Rezoning Transportation Analysis
Petition Number: Insert Zoning Petition #2021-066
General Location Identifier: 14903227

| Revision Log: | Date | Description |
| | 06-24-2021 | Second Review (EL) |

ROC WASH HOLDINGS, LLC
DEVELOPMENT STANDARDS
E1021
REZONING PETITION NO. 2021-066

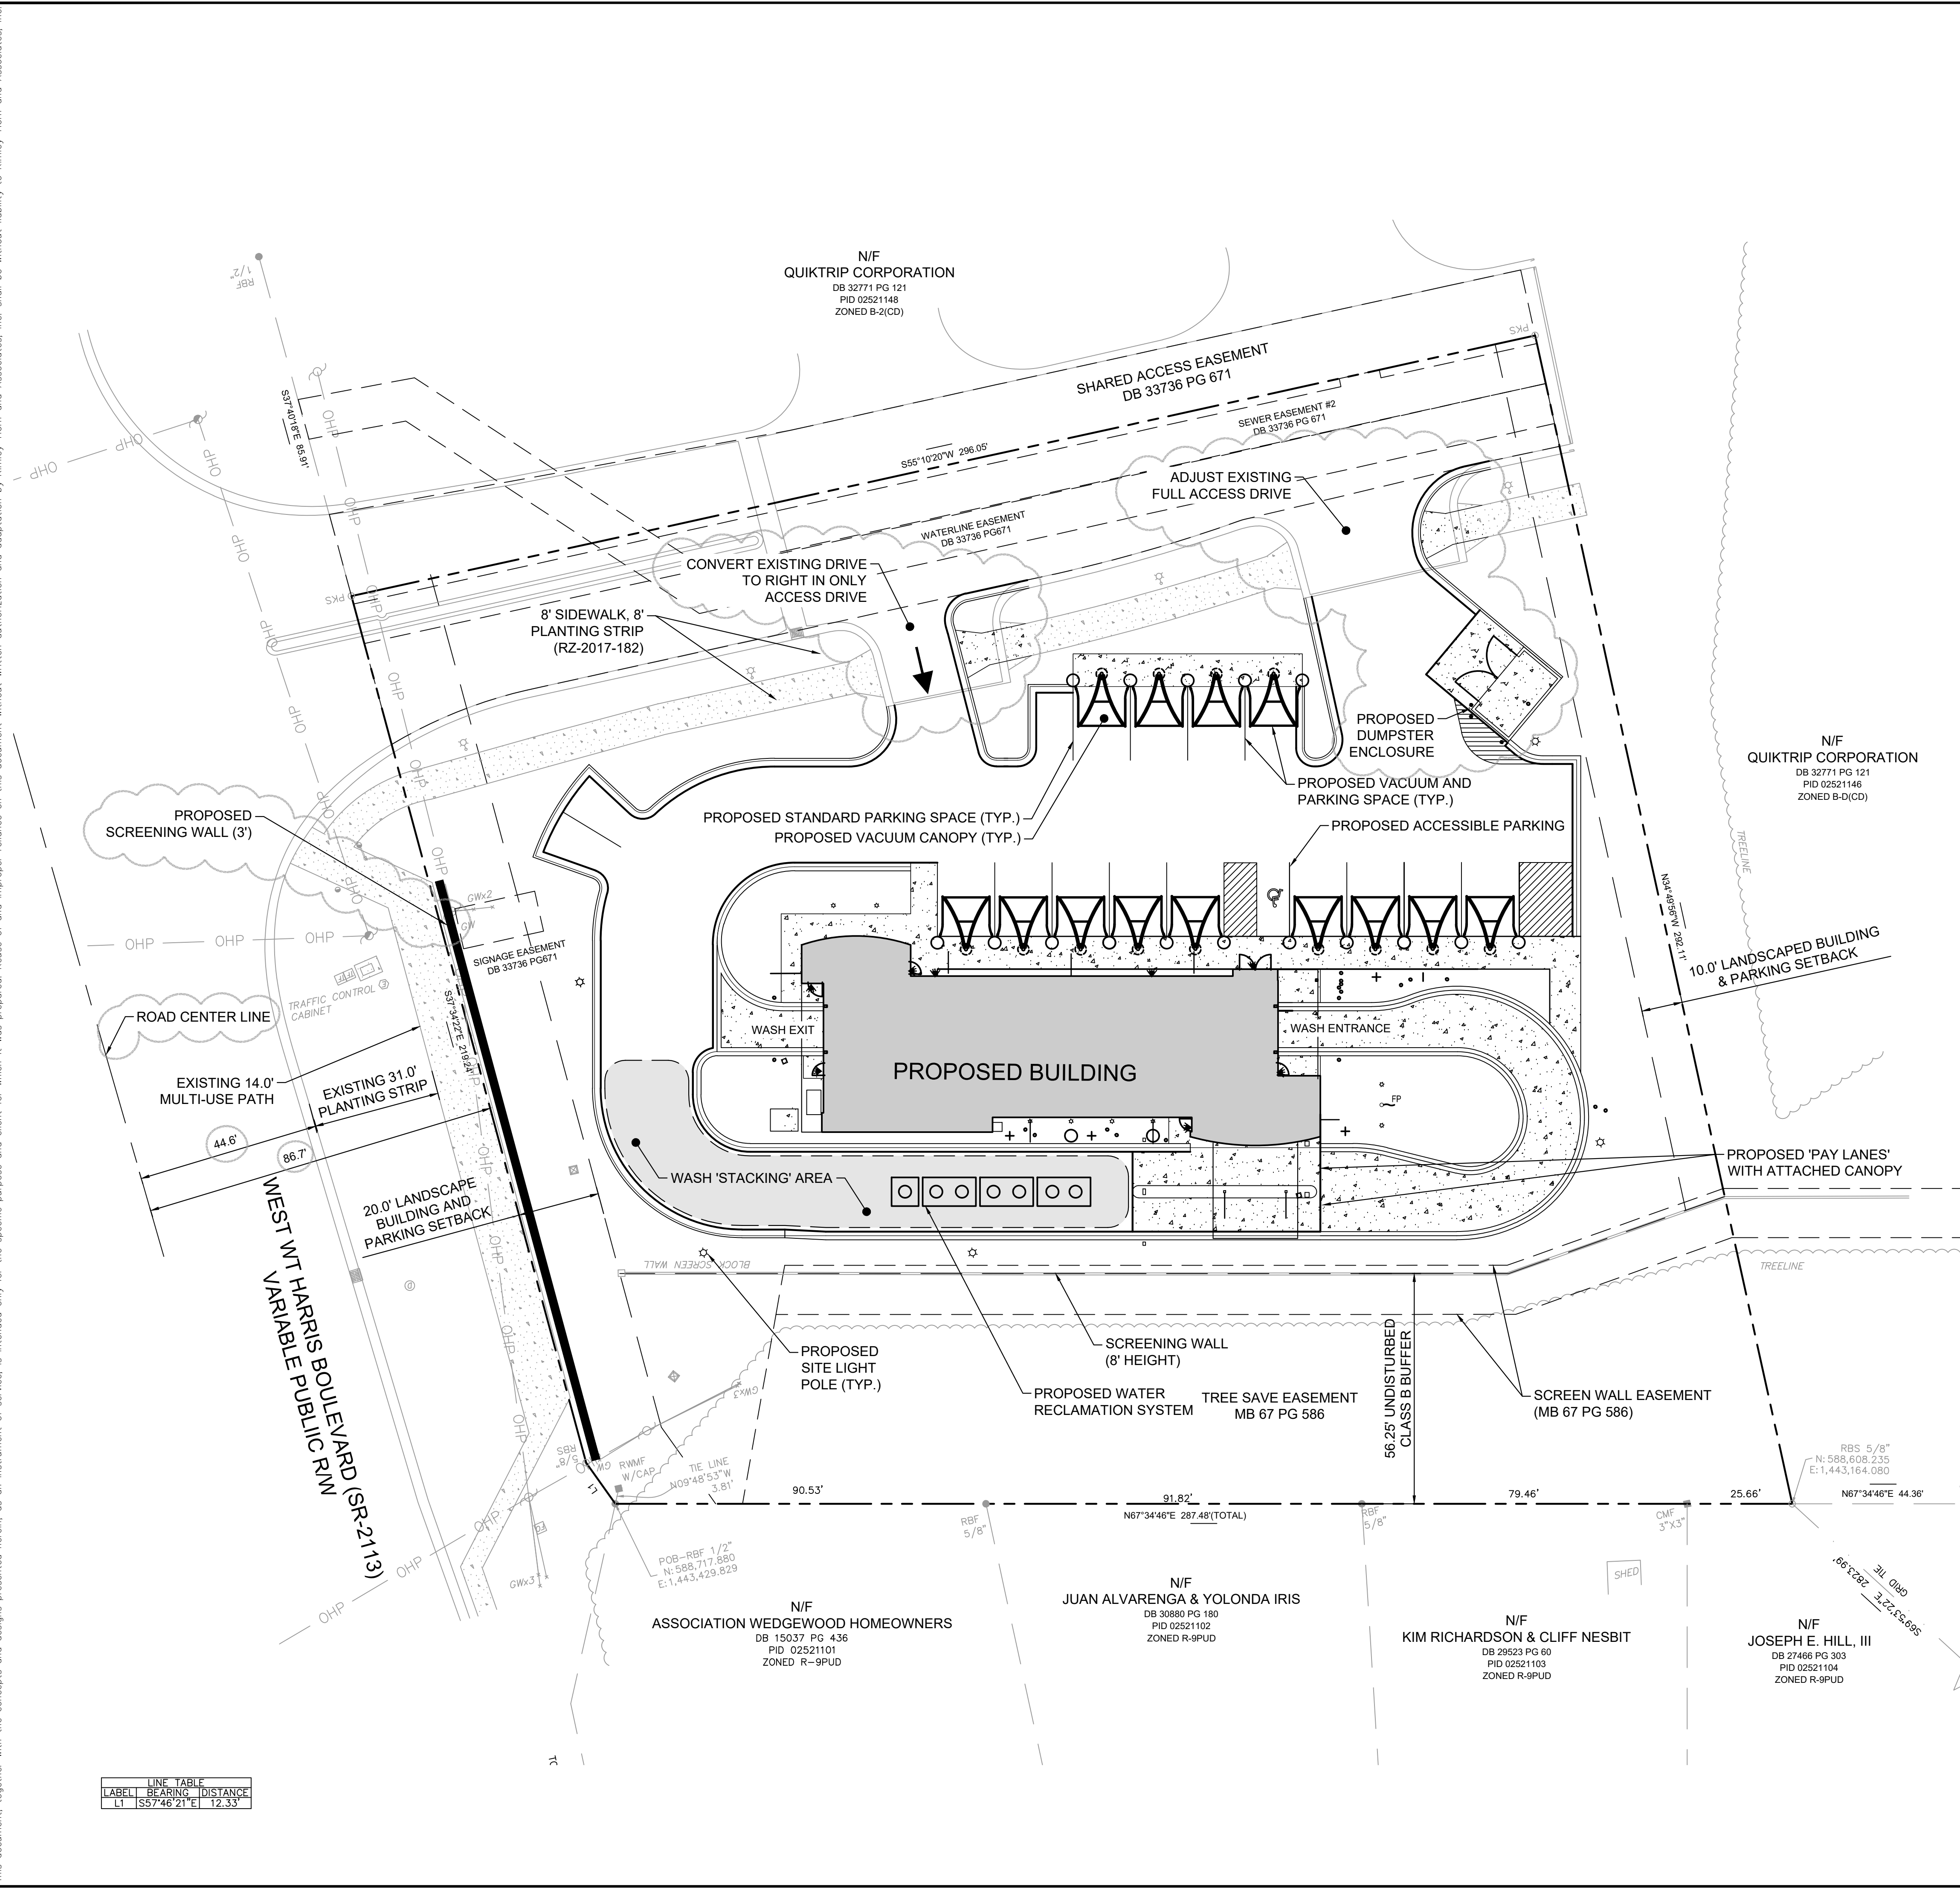
- 3. Updated Comment** (site plan dated 6-14-21): either remove the right in only driveway and keep the full access drive, or keep the right in only access driveway and convert the full access drive to egress only. Revise the conditional note below to update this language to match the revised driveway design. Revise the site plan and conditional note (**Section 3. Access and Transportation (f)**) to modify the proposed access management per the options provided below.
